Kirklees Flood Management & Drainage (Lead Local Flood Authority) – Consultation

Consultation on Application Number: 2018/91661

Address: Land at Walkley Terrace and Brunswick Street, Heckmondwike

Proposal: Proposed residential development - outline application for up to 74 dwellings with means of access to, but not within, the site.

Drawing Title: Proposed Site Plan

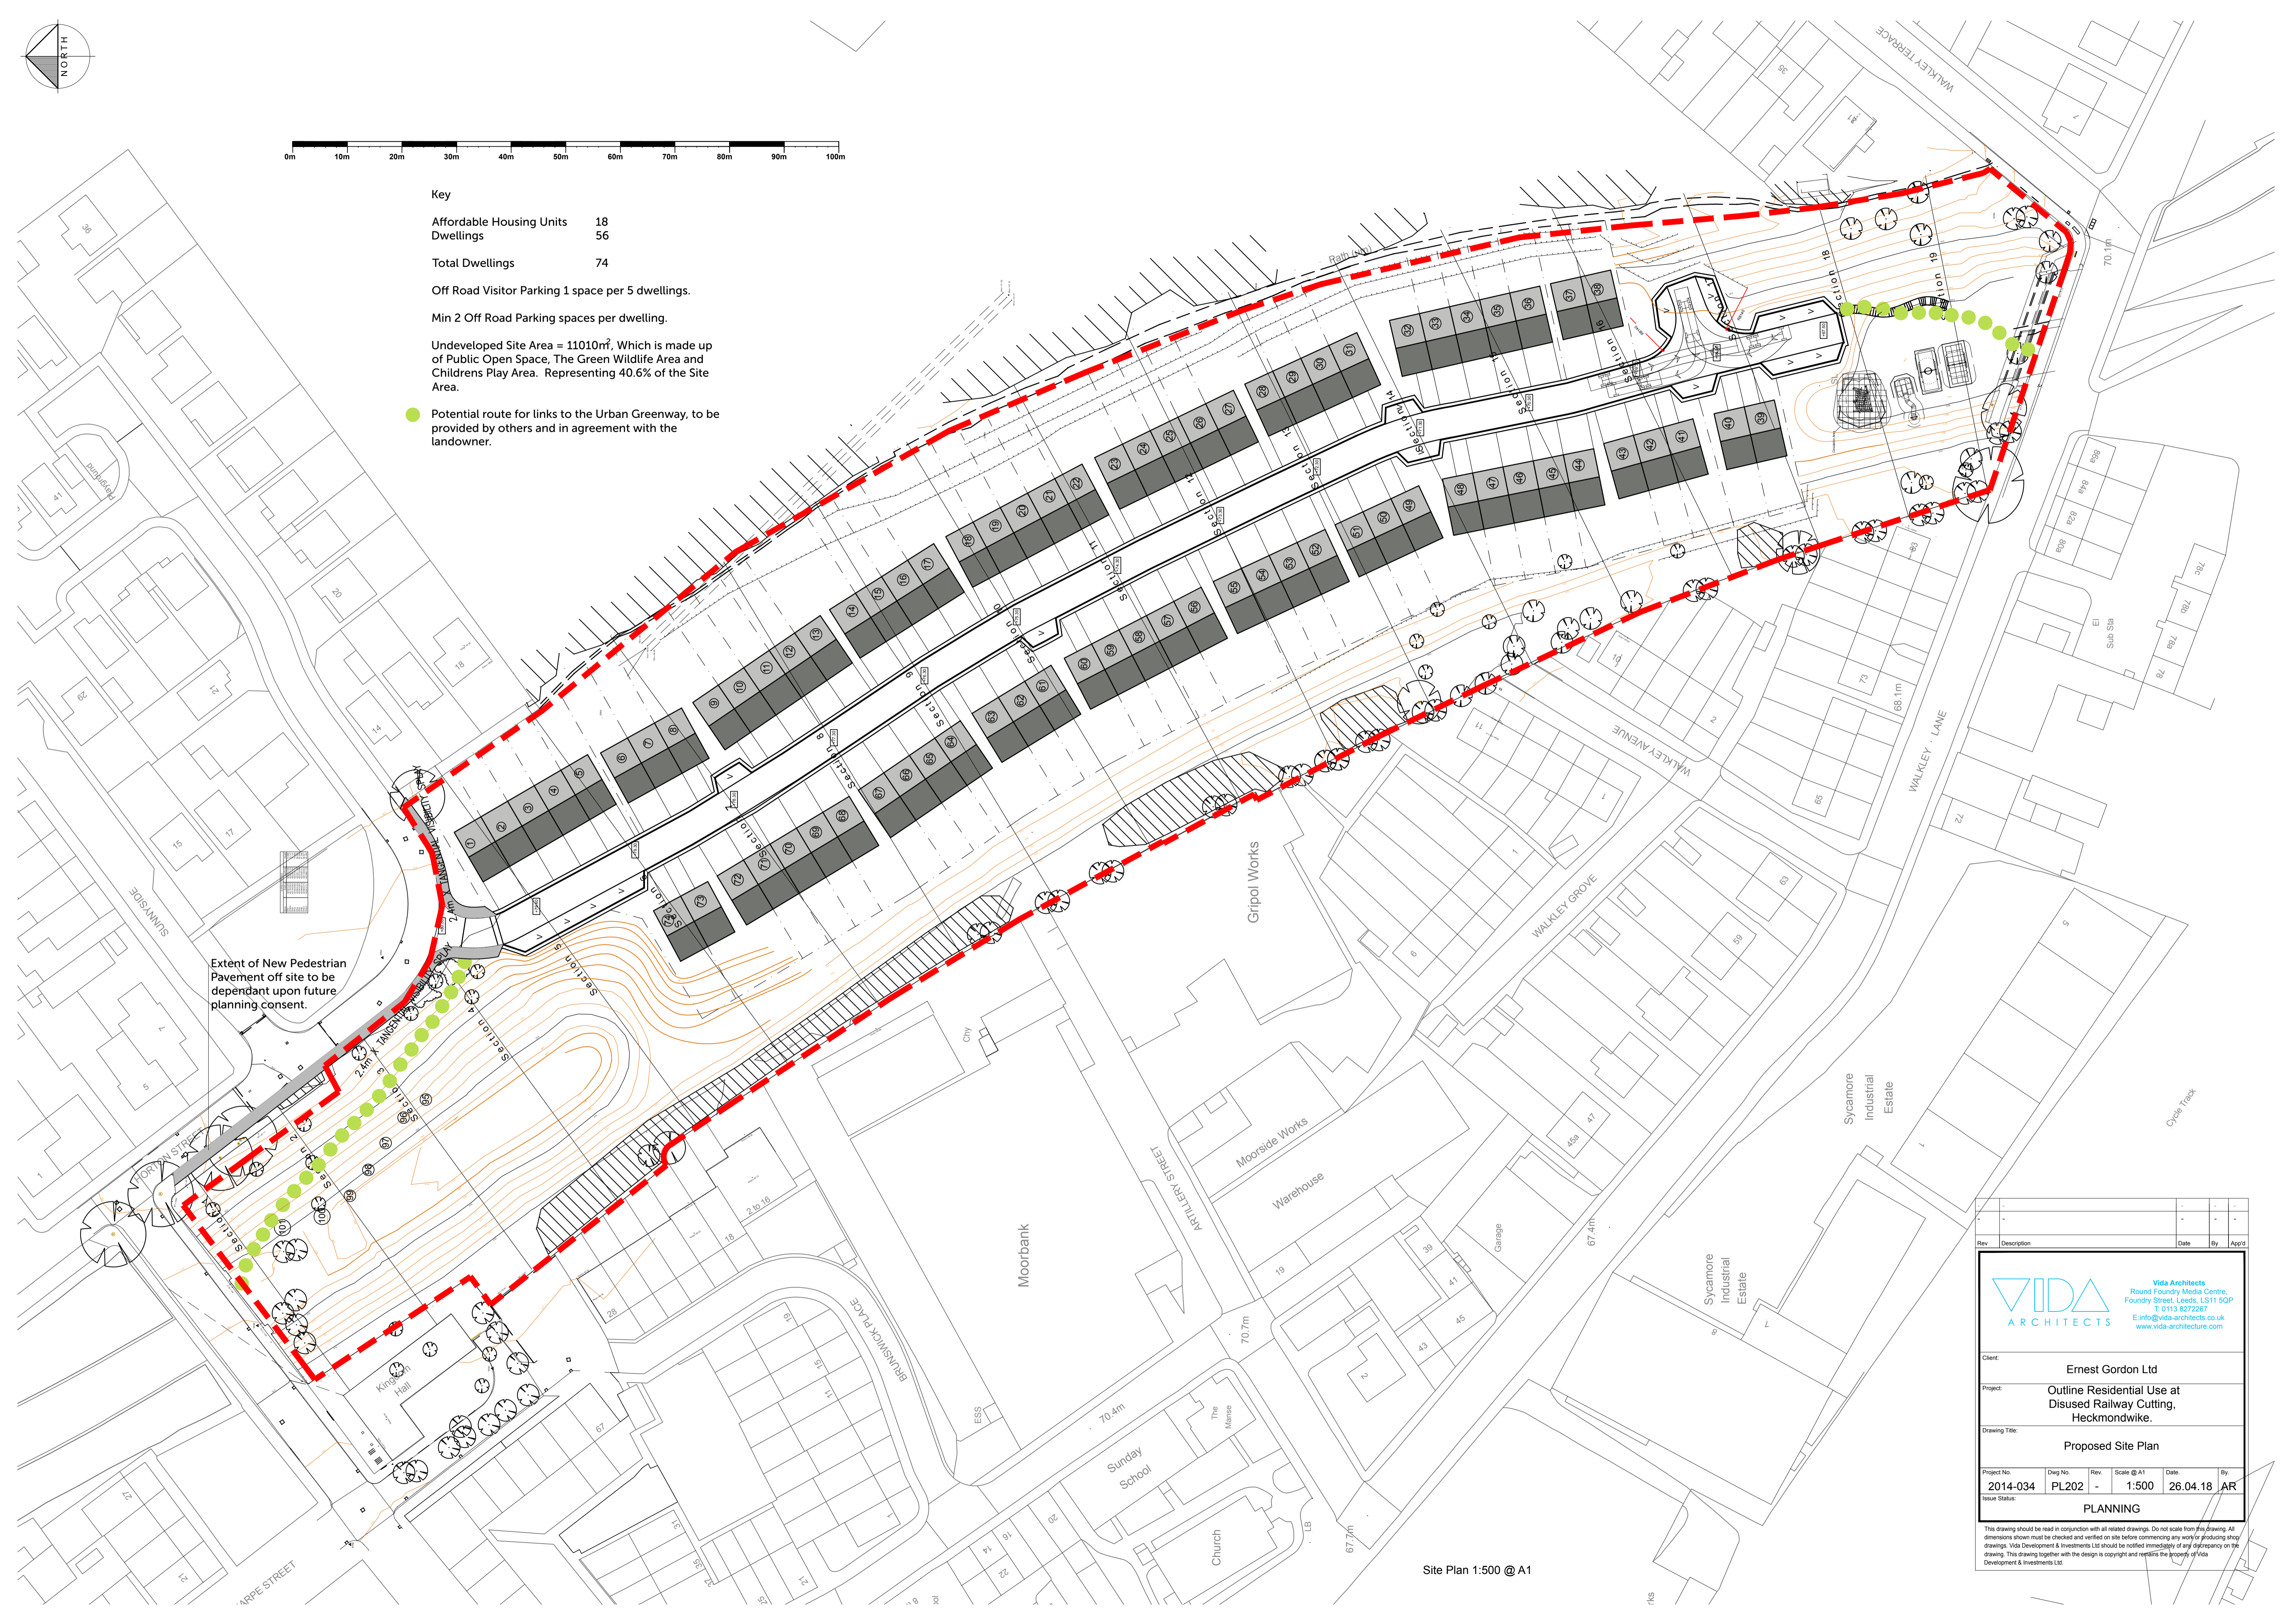
The applicant needs to fully investigate the watercourse shown crossing from the rear of Horton Street to Brunswick Lane. If found to be present and suitable, only a proportion of the site will be able to drain here by gravity.

We are aware of Yorkshire Water comments allowing a discharge to a surface water sewer in Walkley Terrace. However this has to be a gravity connection. That is alluded to but given that previous plans suggest building up levels on the opposite side of the cutting only and Yorkshire Water records indicating a shallow depth to this system (1.3m), the feasibility of this solution is questionable, i.e. exposed bridged pipework or a pumping requirement. Kirklees LLFA would object to a pumped surface water solution for this site.

Further caution to provisional statements is that Yorkshire Water mention the combined sewers in Walkley Lane as a connection point. Walkley Lane is an elevated bridge over the site and would again require a pumped solution for a connection in the road. There are combined sewers either side of the bridge over the site. One runs east and will not be an option by gravity. One runs south toward the Spen Valley Greenway. It is reasonable to assume the Yorkshire Water officer has sanctioned a limited connection to this system downstream of Walkley Lane (the same system). However an 800mm combined sewer, recently installed, also crosses the Greenway, this may prove to be a better option for Yorkshire Water to consider at a detailed stage.

Given that the site falls toward the greenway (they are both old connecting railway lines) a solution is therefore possible but watercourses must be explored in the first instance with the LLFA. We are happy to support this application subject to the investigations described above and the inclusion of appropriate conditions
